Rezoning Transportation Analysis

Petition Number: 2020-145

Date	Description
11-30-20	First Review (LJ)
12-28-20	Second Review (LJ)
01-26-21	Third Review (LJ)

RZ-2

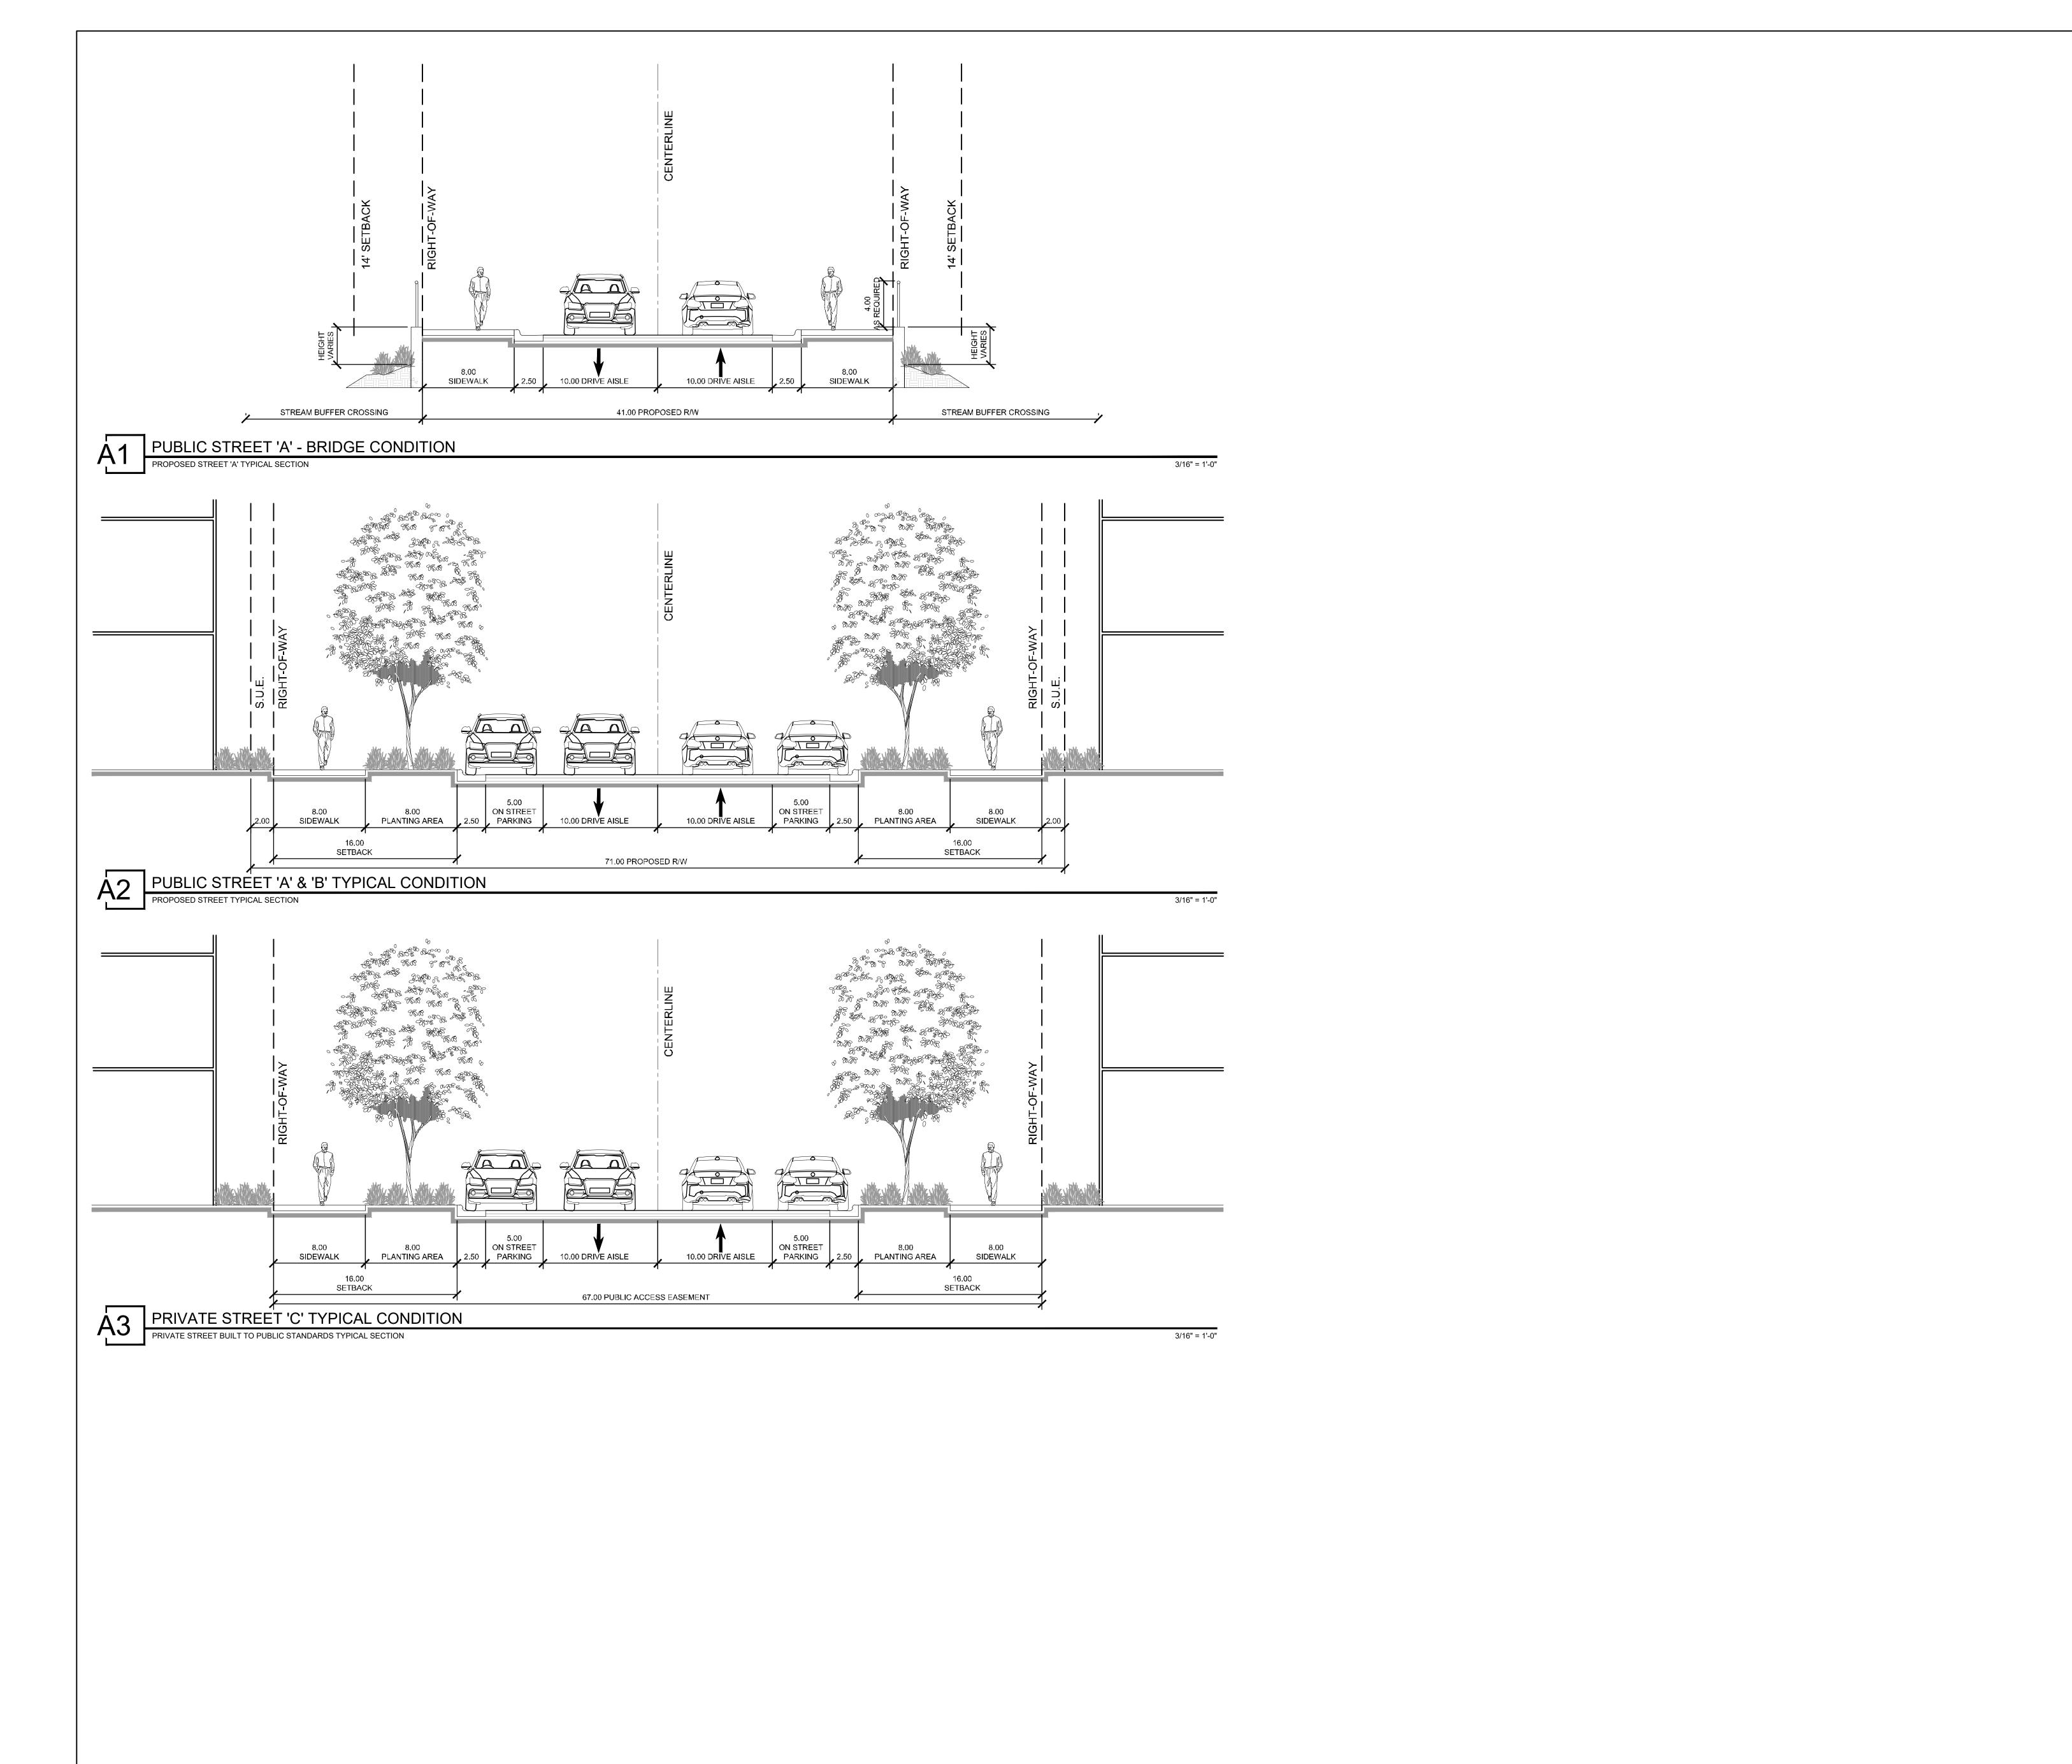
7. **OUTSTANDING, per III. Transportation, 5., f. (01/26/2021):** Add a site plan note(s) specifying dedication and fee simple conveyance of all rights-of-way to the City before the site's first building certificate of occupancy is issued is needed. ~~CDOT requests rights-of-way set at 2' behind back of sidewalk where feasible.~~

8. **OUTSTANDING, per III. Transportation, 5., f. (01/26/2021):** Add a site plan note specifying that all transportation improvements will be approved and constructed before the site's first building certificate of occupancy is issued is needed. The petitioner may phase transportation improvements if said improvements and phasing are explicitly described in site plan notes.

9. **NEW COMMENT (01/26/2021):** Petitioner shall remove note, III. Transportation, 5. f.
